KITITAS COUNTY

MEMORANDUM

SUBJECT: Hawkins Short Plat SP-09-00018

HAWKINS SHORT PLAT
PART OF SECTION 30, T. 17 N., R. 20 E., W.M.
KITTITAS COUNTY, WASHINGTON

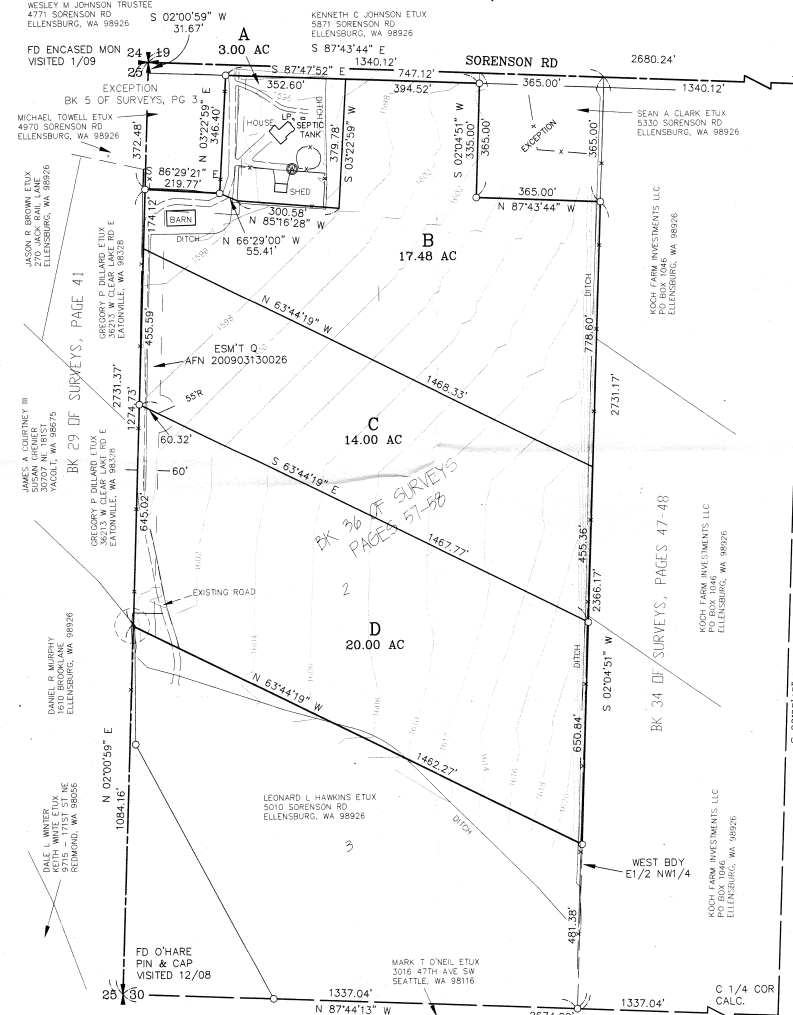
3. Private Road Improvements: Access from Sorenson Road to the cul-de-sac shall be constructed as a Low-Density Private Road. See Kittitas County Road Standards, 9/6/05 edition.

- a. Access easements shall be a minimum of 60' wide. The roadway shall have a minimum width of 20', with 1' shoulders, for a total width of 22'.
 - b. Minimum centerline radius will be 60'.

- c. The surface requirement is for a minimum gravel surface depth of 6".
 - d. Maximum grade is 12%.
 - e. Stopping site distance, reference AASHTO.
 - f. Entering site distance, reference AASHTO.

- j. All easements shall provide for AASHTO radius at the intersection of county road.
 - k. A paved apron shall be constructed at the intersection of the proposed private intersection and the county road right of way.

4. Cul-de-Sac: A cul-de-sac turn-around having an outside right-of-way or easement diameter of at least 110 feet shall be constructed at the closed end of all dead-end roads serving 3 or more lots. The driving surface shall be at least 96 feet in diameter. Cul-de-sacs must also conform to the requirements specified by the 2006 International Fire Code. Contact the Fire Marshal regarding any additional cul-de-sac requirements.
